Recommendation Report for Planning Permission for Works or Extension to a Dwelling

REF NO: K/26/18/HH

LOCATION: 87 Golden Avenue
East Preston
BN16 1QT

PROPOSAL: Two storey rear extension

FIRST FLOOR PLAN

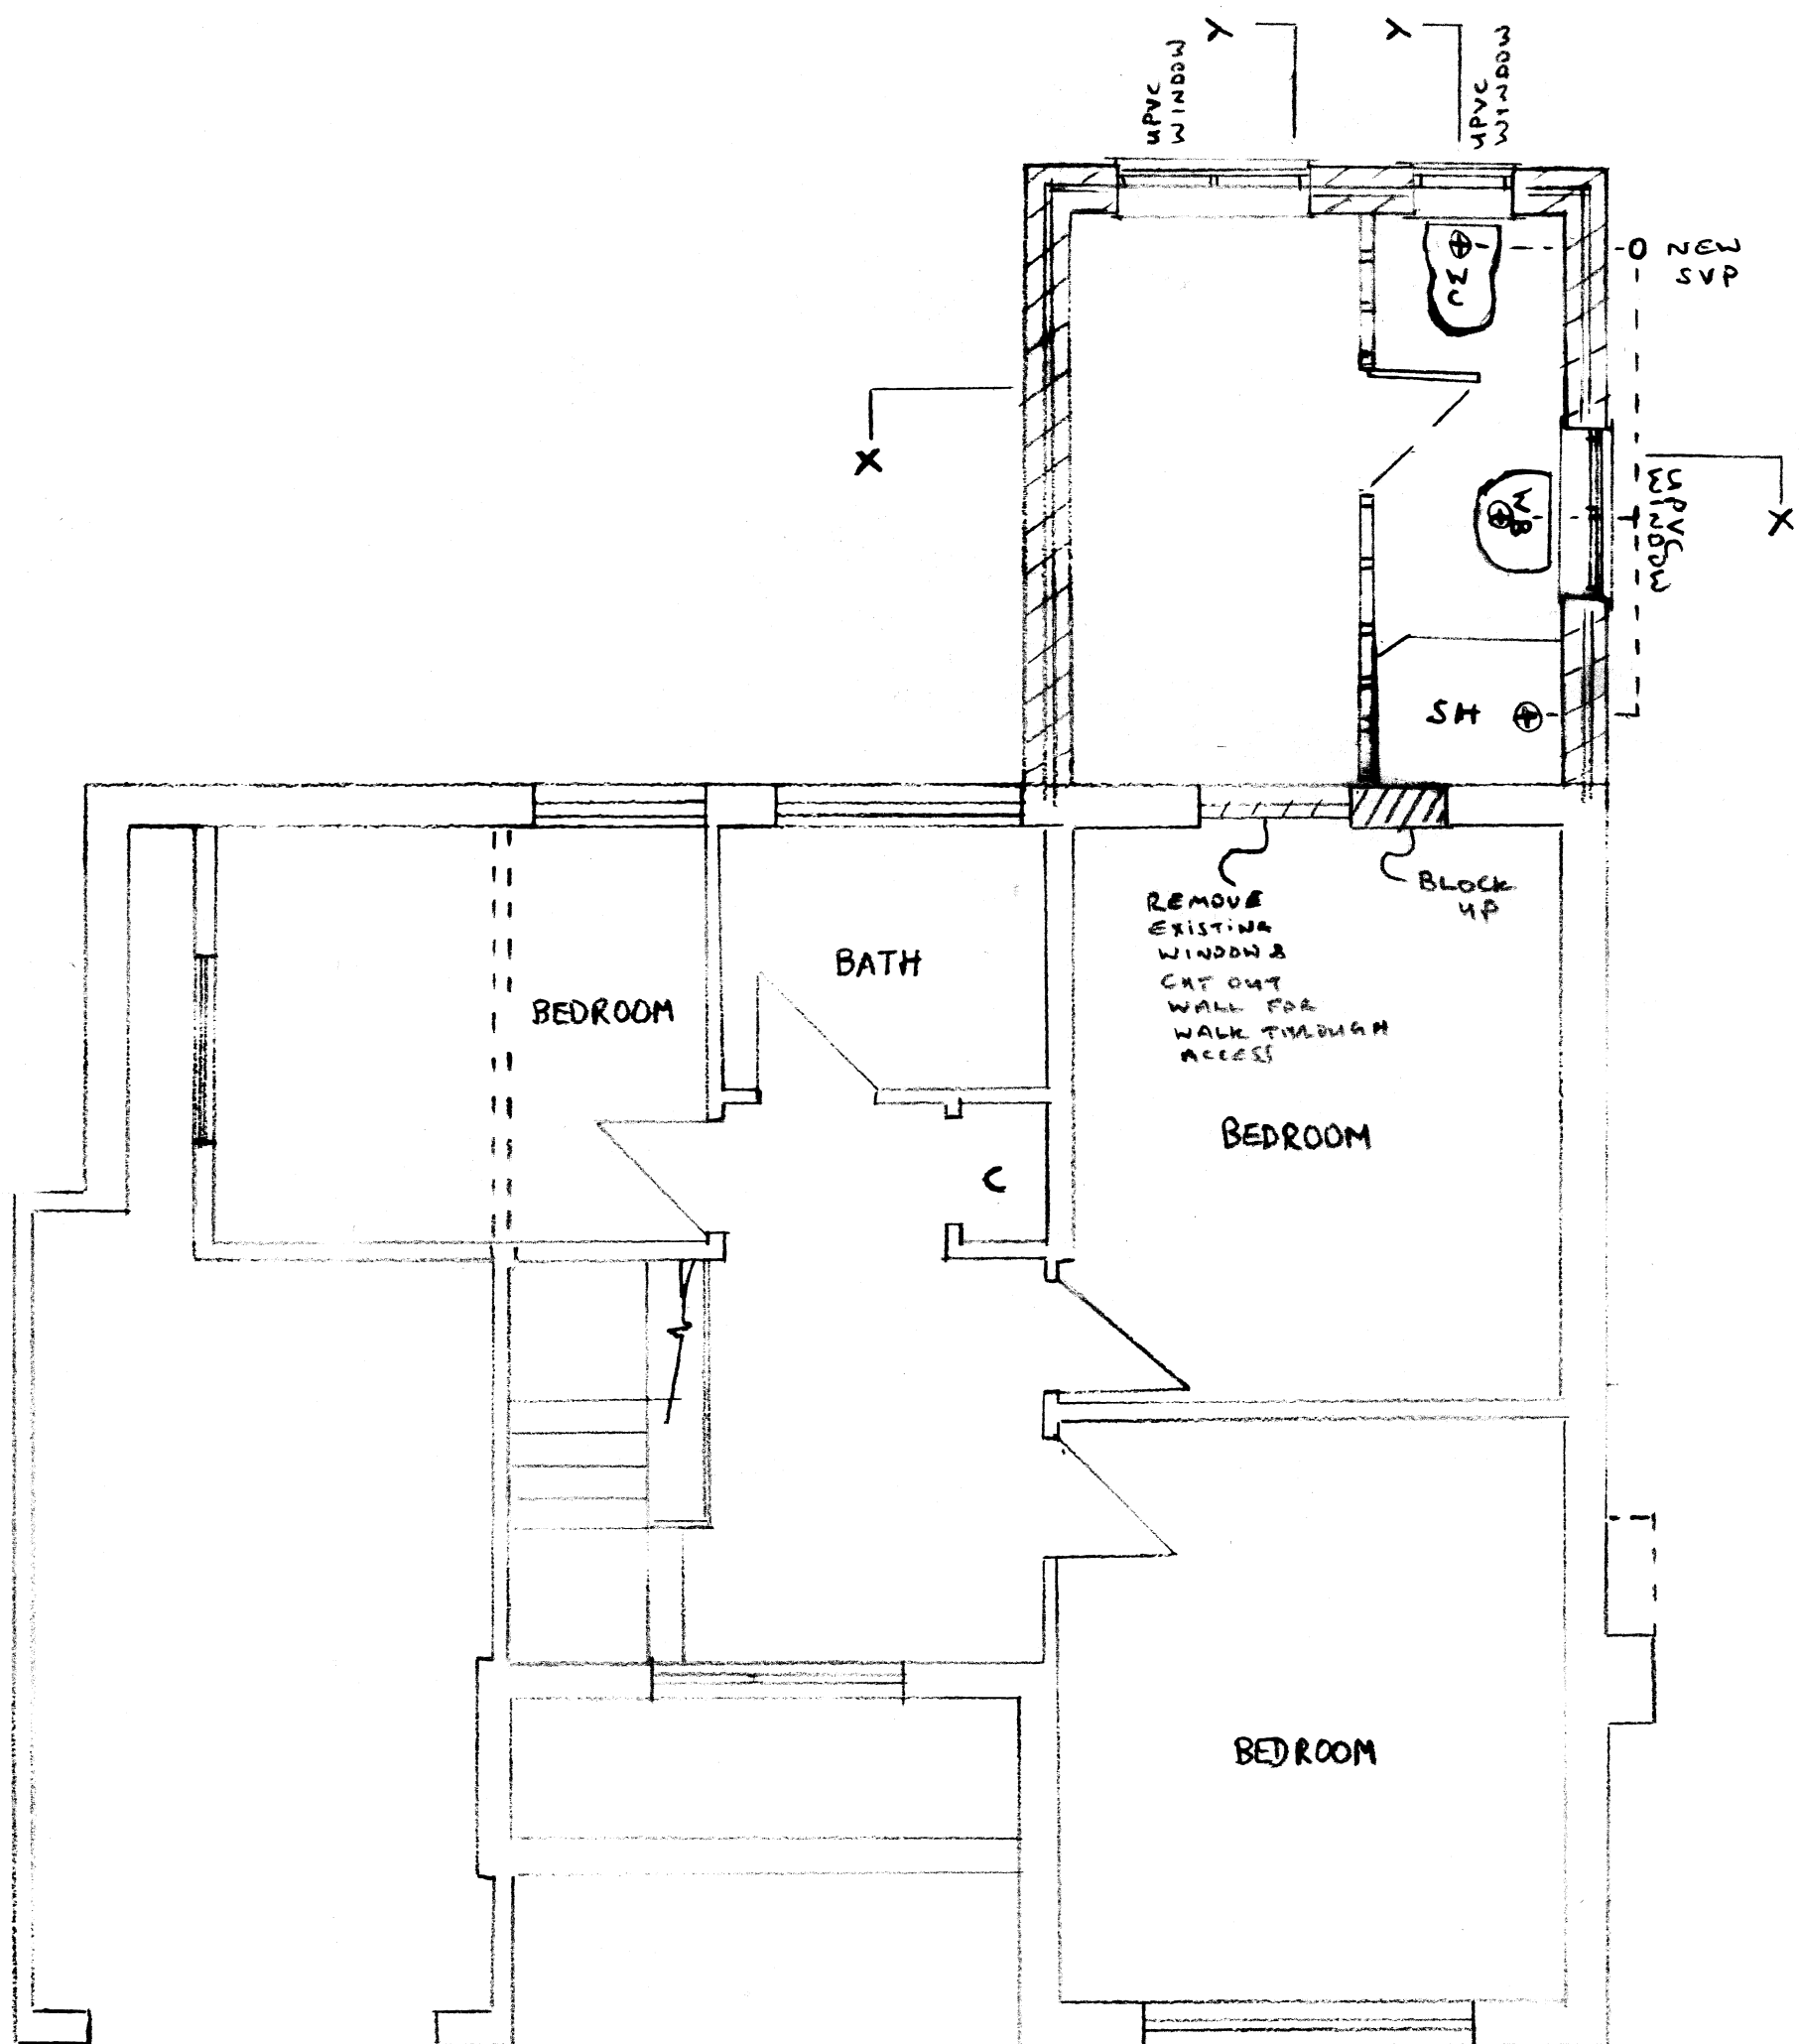
The proposed extension is not considered to give rise to any significantly adverse impact on the neighbouring dwellings other than the proposed South-facing window, serving a bathroom, provides views directly facing the neighbouring dwelling, however, this issue will be dealt with via condition. The impact of overlooking from the rear is no worse than that resulting from the existing dwelling.

Reason: In the interests of amenity in accordance with policies D DM1 and D DM4 of the Arun Local Plan.
- 4 The window at first floor level in the Southern elevation of the building shall at all times be fixed shut and remain glazed entirely with obscure glass below 1.7m.
